Flying Horse North Maintenance Building (REVISED), PPR-19-034

Please accept the following comments from El Paso County Public Health for the special use request referenced above:

Mike McCarthy
Environmental Health Division
El Paso County Public Health
719.575.8602
mikemccarthy@elpasoco.com
10Oct2019

SD1.0
Site Development
Plan
Scale
1" = 20'-0"

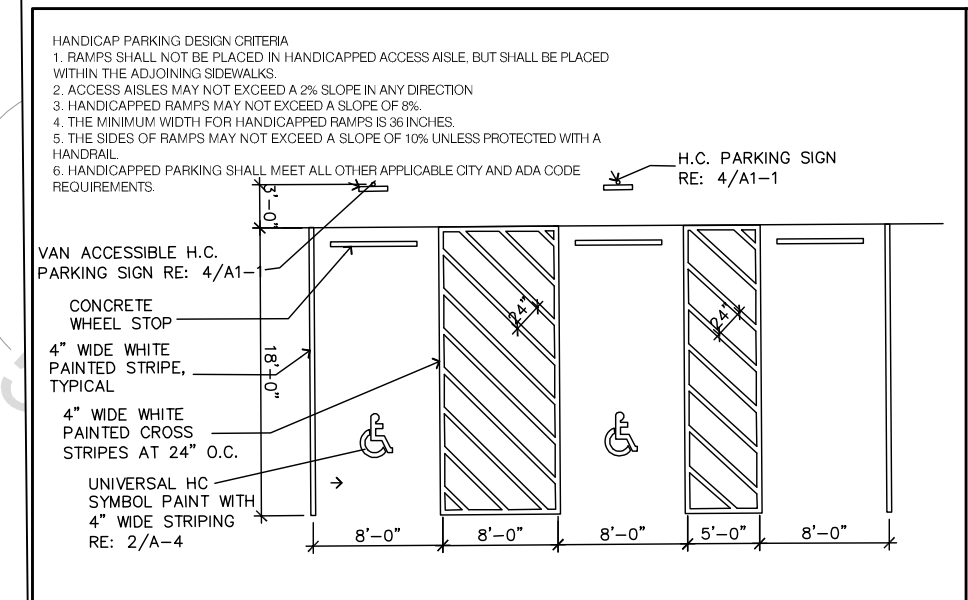
- **Wastewater service is an onsite wastewater treatment system designed by a Colorado Registered Professional Engineer as the system is for commercial use. The soil treatment area must be located in an area not subject to compaction by carts, vehicles and maintenance equipment. The design must comply with the Onsite Wastewater Treatment System (OWTS) Regulations, Chapter 8 of the El Paso County Board of Health Regulations.**

- **Water service is from a well not located on the same lot. All water line extensions on to the maintenance building must meet the setback requirements from all applicable wastewater components and piping.**
